NORTH FALLS OFFSHORE WIND FARM

**Appendix C8.1 to the Natural England Deadline 8 Submission**  
**Natural England's Benthic Ecology Advice on the Applicant's Deadline 7 Documents**

Planning Inspectorate Reference EN010119

23 July 2025

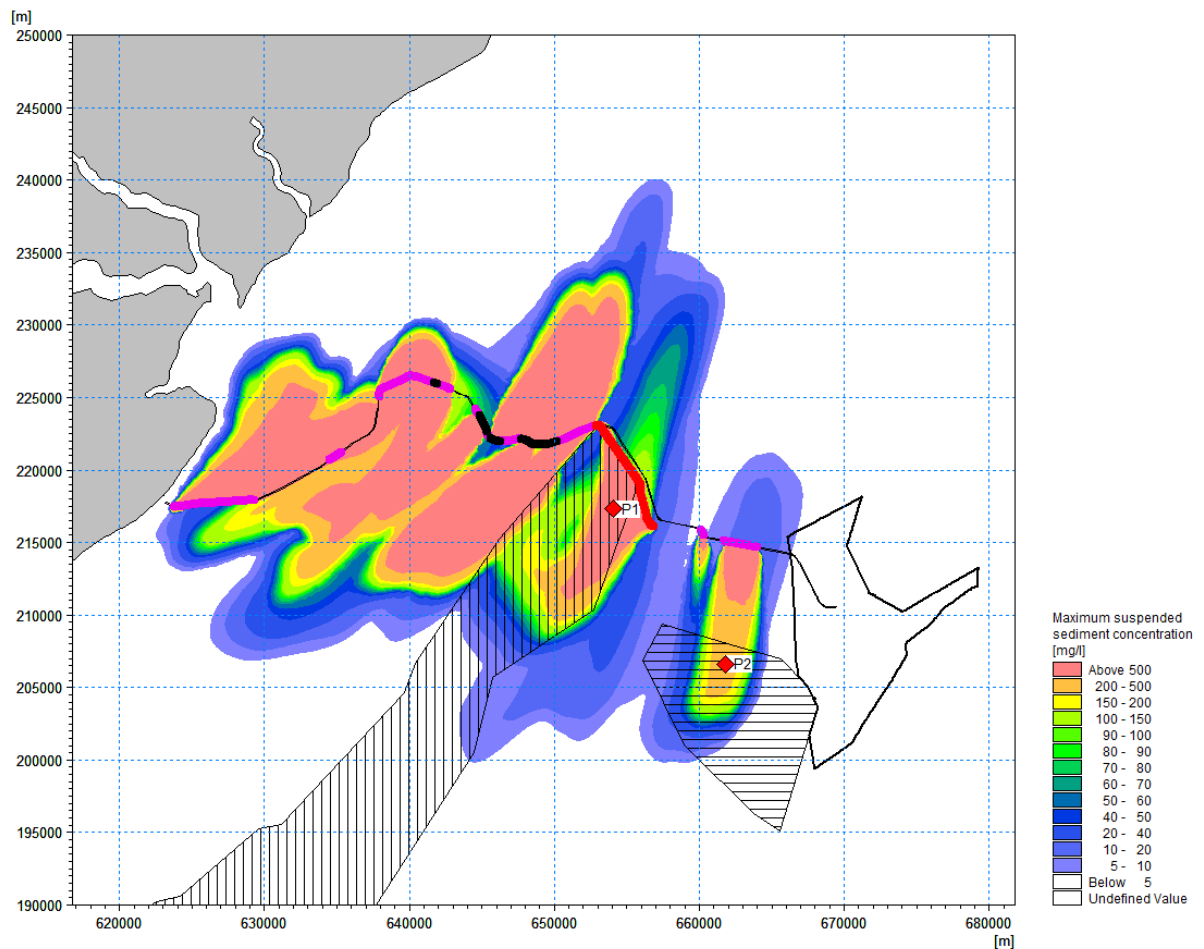
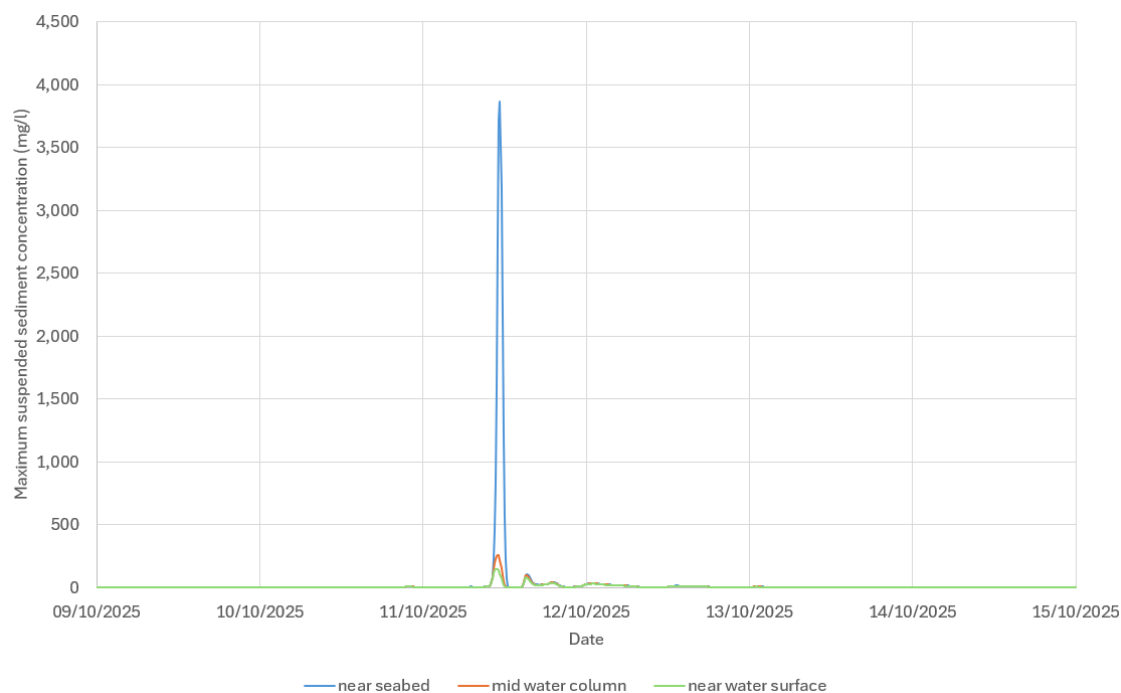
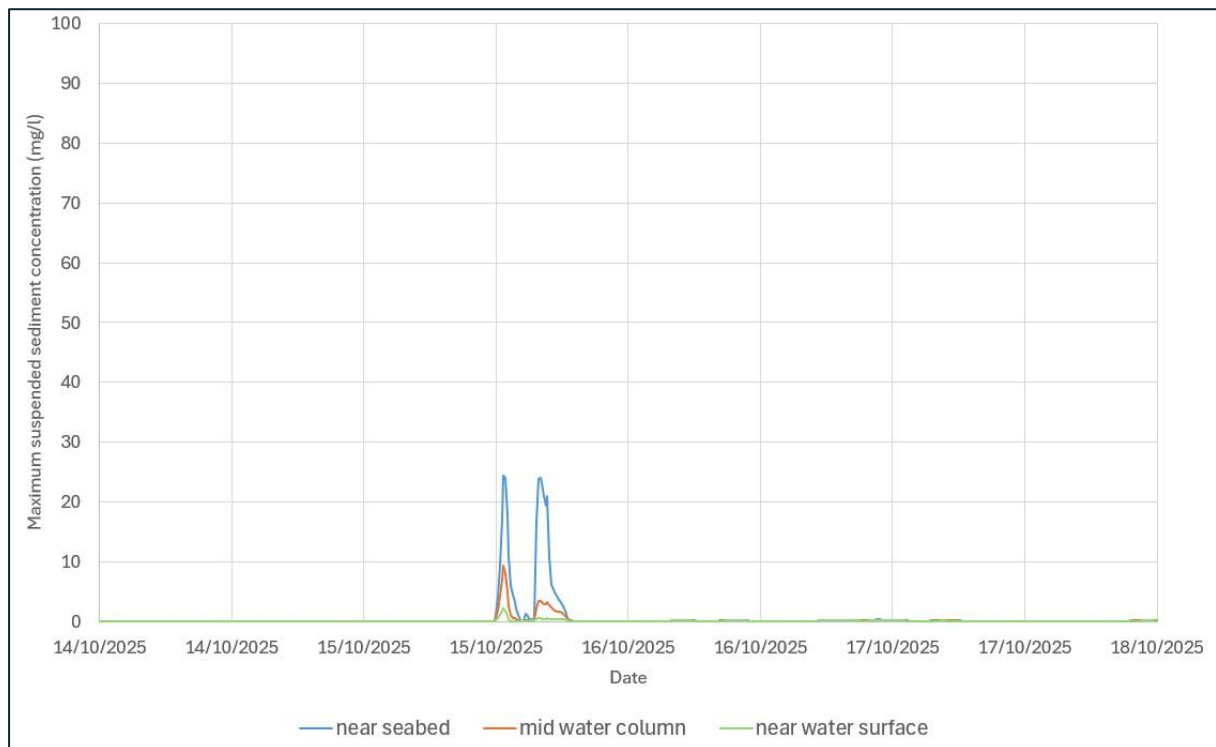
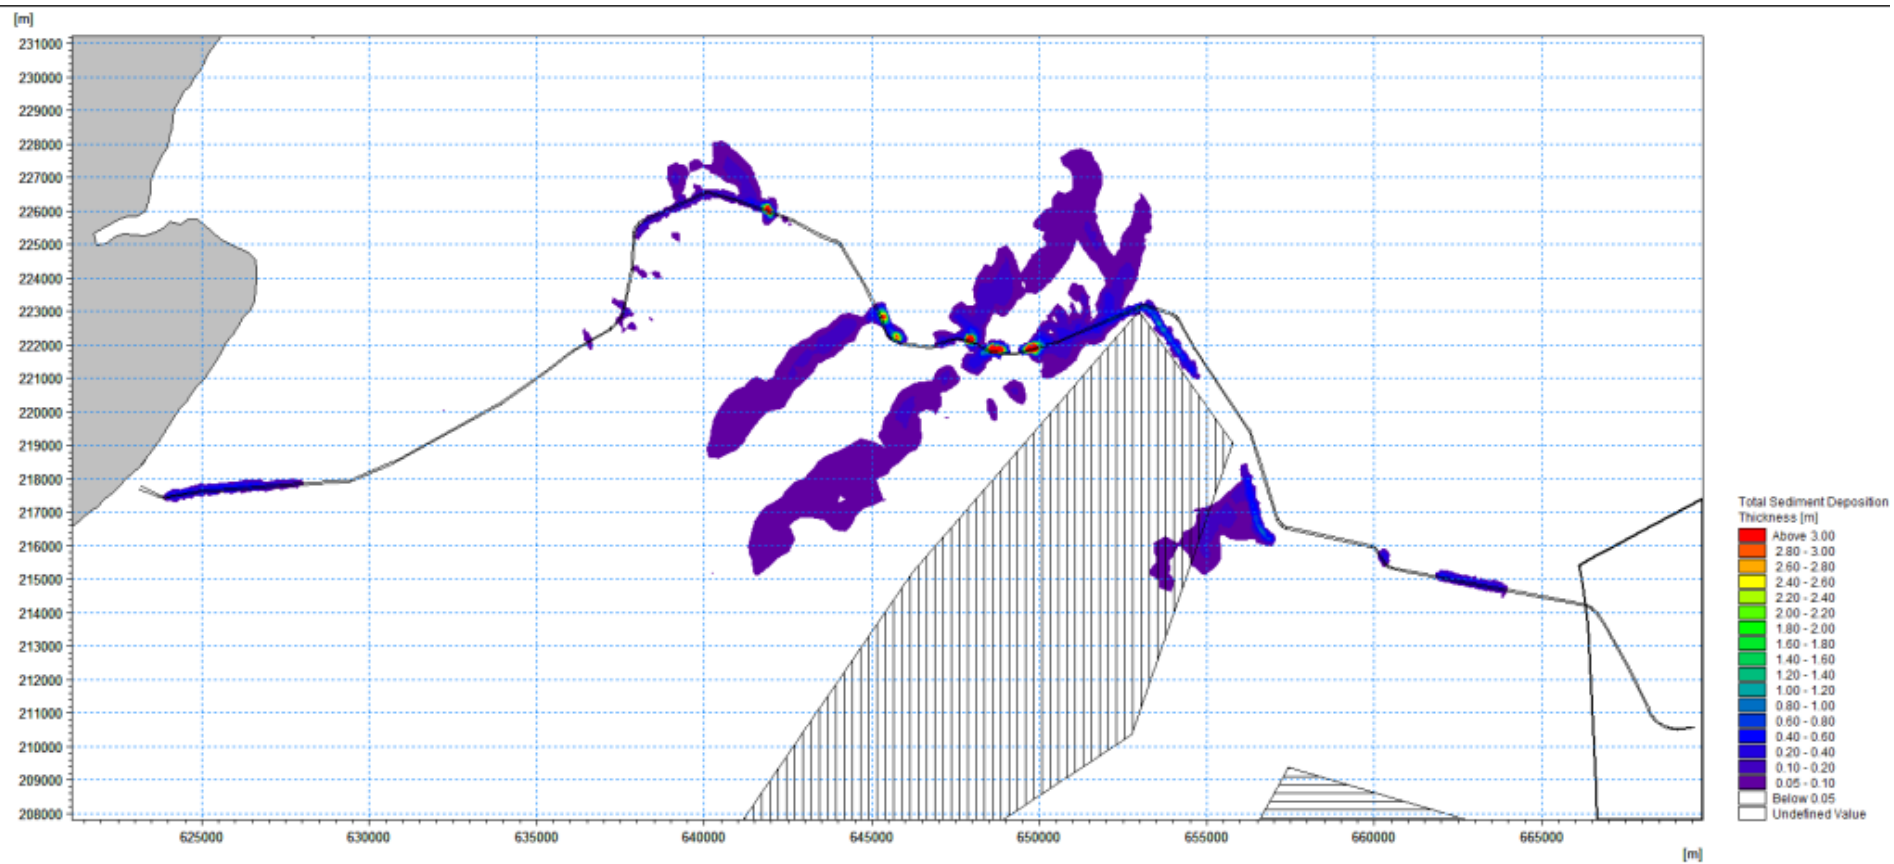
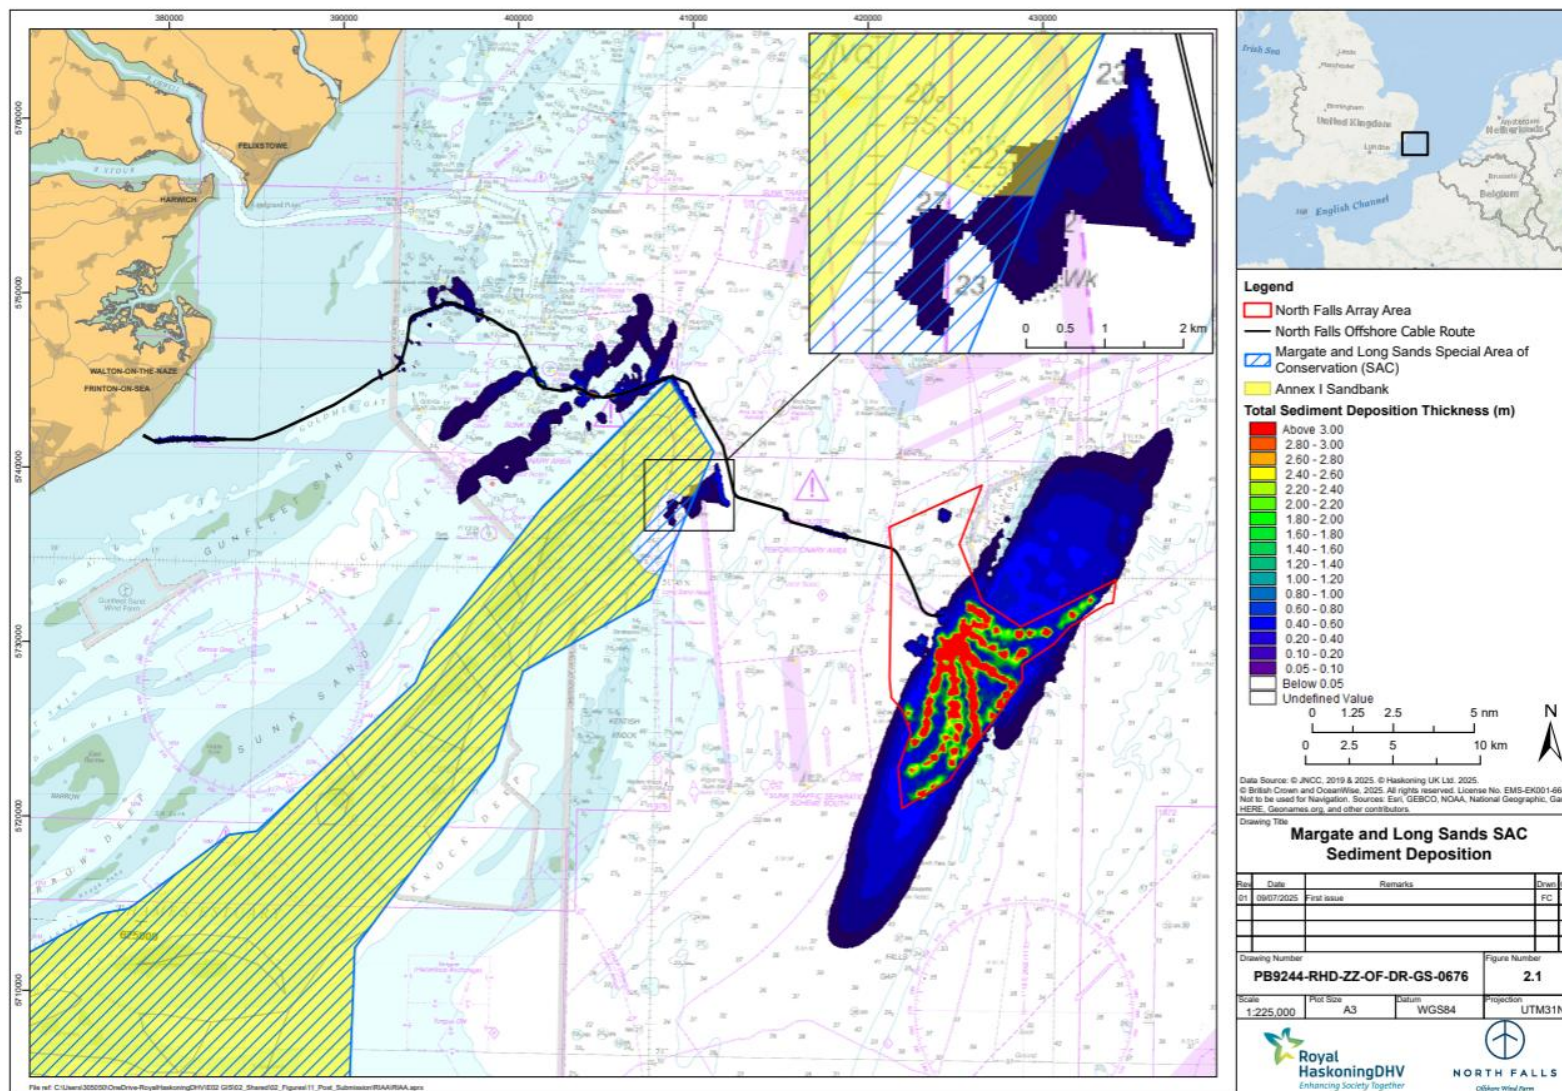
4	<p>RIAA Paragraphs 50 to 60,</p> <p>Hydrodynamic and Sediment Dispersion Modelling Report, Document Reference 9.54, Rev 2 [REP7-042] Figure 7-12</p>	<p>Natural England is concerned that contradictory information has been presented between the Hydrodynamic and Sediment Dispersion Modelling Report, and the RIAA Part 2.</p> <p>Natural England notes that within the RIAA <i>“Deposition of SSCs arising from the above works could result in 5cm to 15cm sediment depth in an area of c. 1.5km<sup>2</sup> (0.23% of the SAC) overlapping the MLS SAC, as shown by the sediment dispersion modelling (Hydrodynamic and Sediment Dispersion Modelling Report, <b>Document Reference 9.54, Rev 02</b>).”</i> However, within the modelling report it is stated that <i>“Figure 7-12 shows the total sediment deposition thickness greater than 5cm which occurs during export cable trenching activities. All sediment deposition occurs within the export cable corridor and is &lt;5cm”</i>.</p> <p>We also note that the Applicant’s conclusion that <i>“there is no potential for an AEol of this attribute due to increased SSC and sediment deposition,”</i> has not been supported with consideration of the ecological implications or sensitivity of the species present. For example, the predicted deposition has not been set in the context of MarESA pressure benchmark thresholds for smothering or considered in light of the specific communities present and their likely sensitivity to the depths of deposition that are predicted.</p>	<p>Natural England advises that the information provided should be made consistent and the WCS clarified across the relevant documents.</p> <p>Overall, however, we advise that whilst the updated RIAA has not considered the ecological implications of the predicted sediment deposition within MLS SAC, we believe that the risk of an AEol due constructed-related activities is low.</p>
